CAMPBELL'S RIDGE COMMUNITY - LOT 12

Townsend Model – Elevation 2

2nd Floor Framing — Rear 10' x 8' Sliding Glass Door Header

M+K Project #: 126-24045 (40/02)

2ND FLOOR FRAMING PLAN
SCALE: 1/8" = 1'-0"

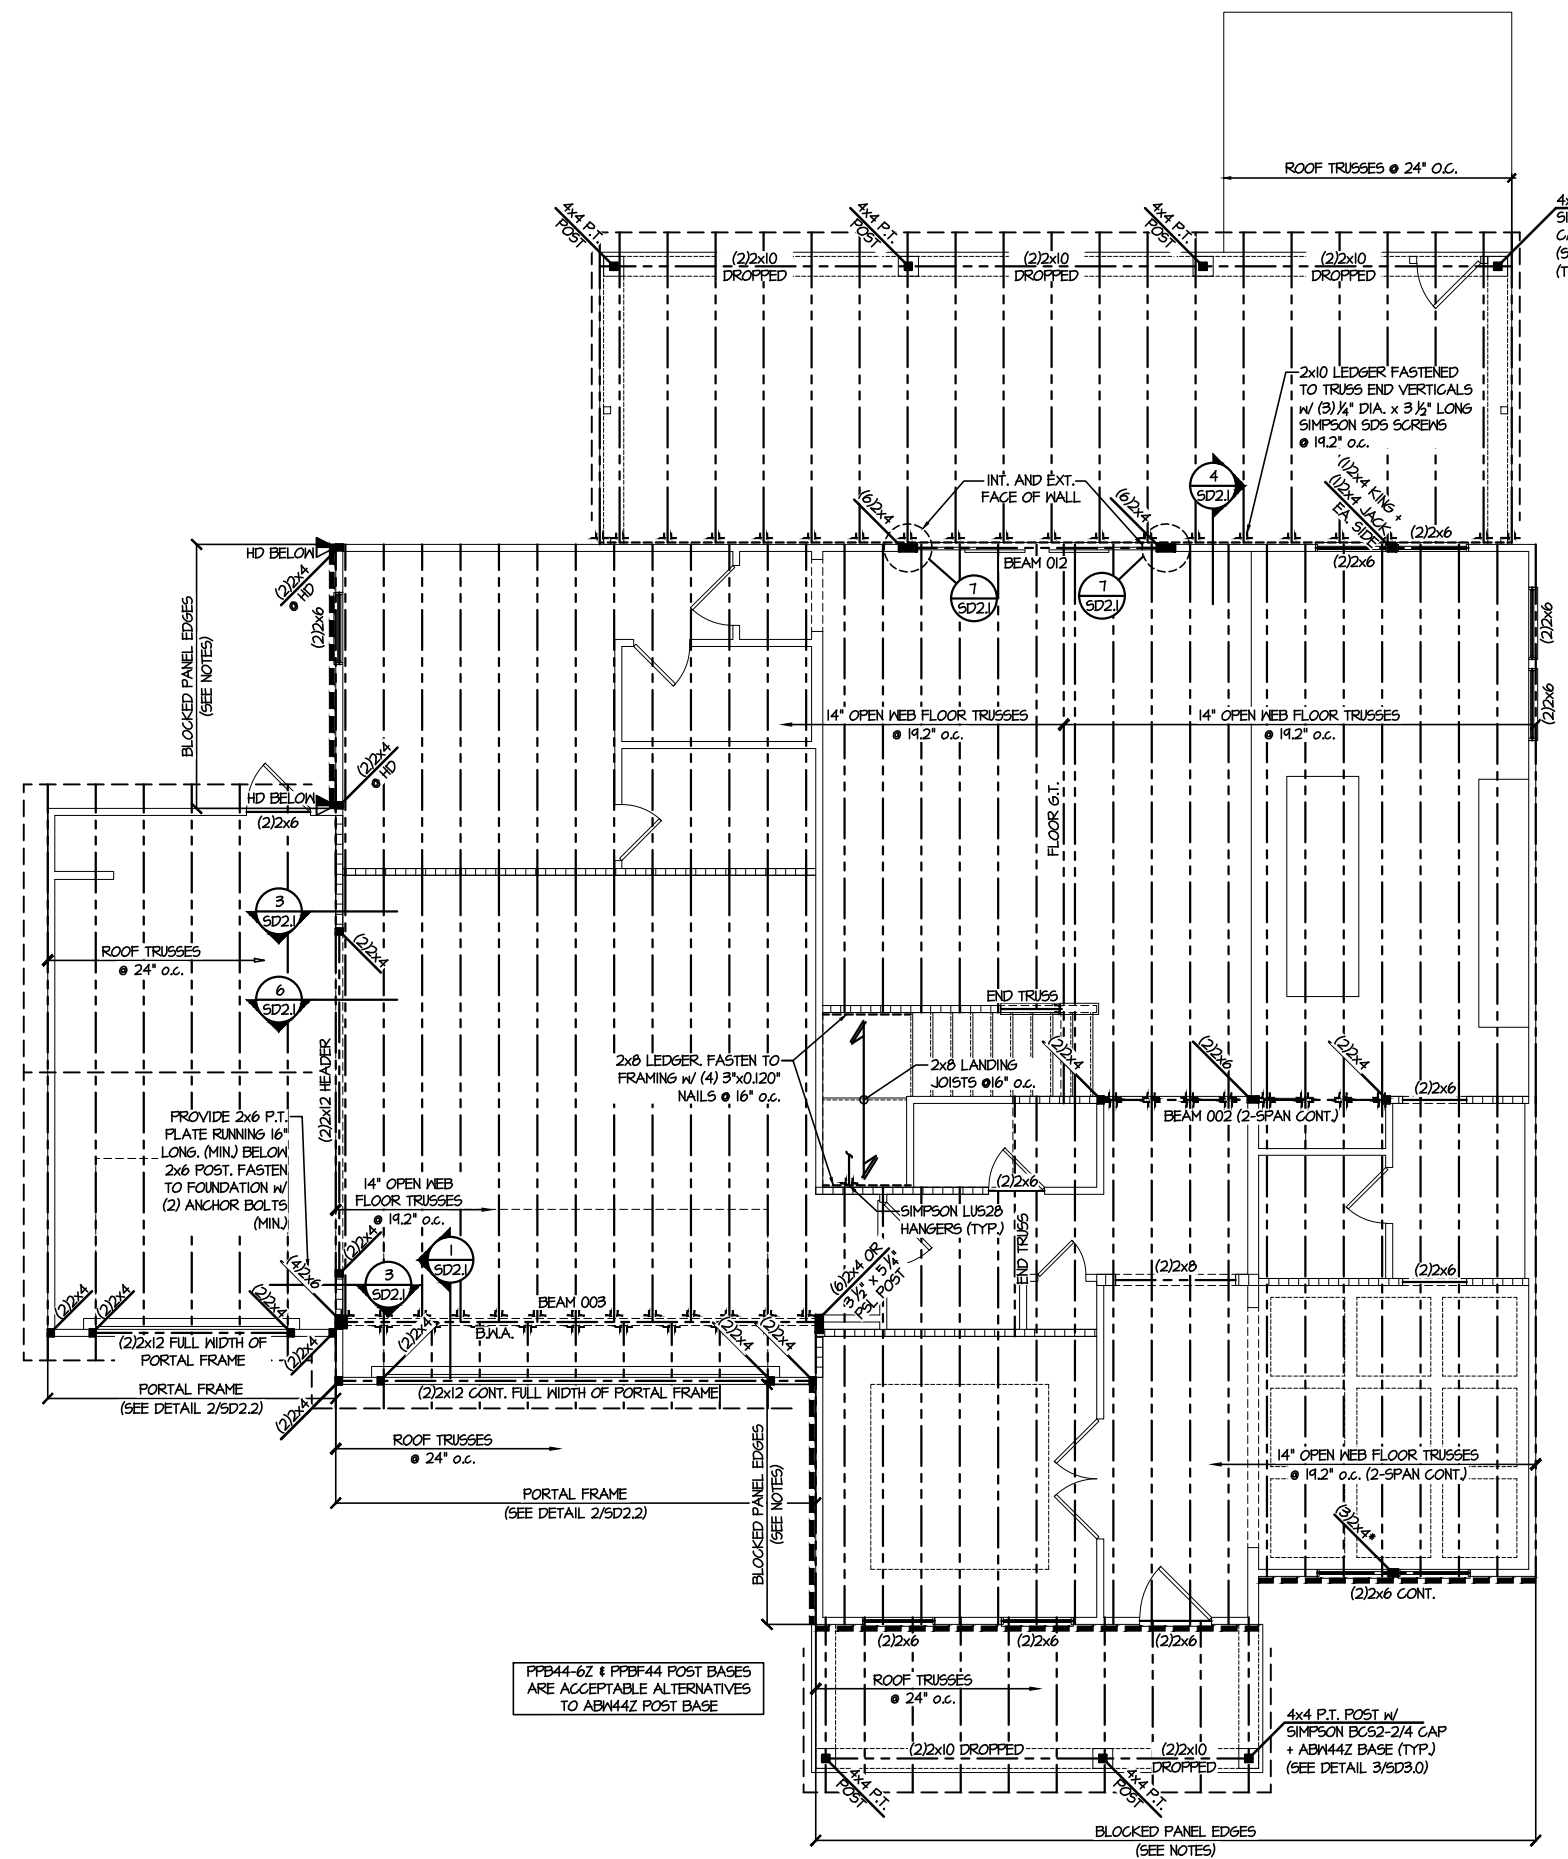
Pursuant to your request, we have prepared this letter to address the 2nd floor framing plan at the rear 10' x 8' sliding glass door header. It was reported to us, by you, that with the (2) 1 3/4" x 14" LVL header that is called out on the structural plans there is not enough clearance to install the door below.

We have analyzed the rear 10' x 8' sliding glass door header for a (2) 1 3/4" x 11 1/4" LVL in lieu of the (2) 1 3/4" x 14" LVL that is called out on the structural plans, and it is our professional opinion that the shallower 11 1/4" header is adequate to support the code required loads. The existing header may be removed and replaced with the shallower sized header. Alternatively, the bottom of the existing header may be notched for the installation of the door as required (2" maximum). Contractor is to start notch at corner of door opening below with a 1" diameter hole drilled prior to making straight cuts. Contractor must not over cut notch. Existing horizontal straps shall be removed and adjusted to new depth of notched beam. Provided additional blocking as required for adjusted horizontal strap connection.
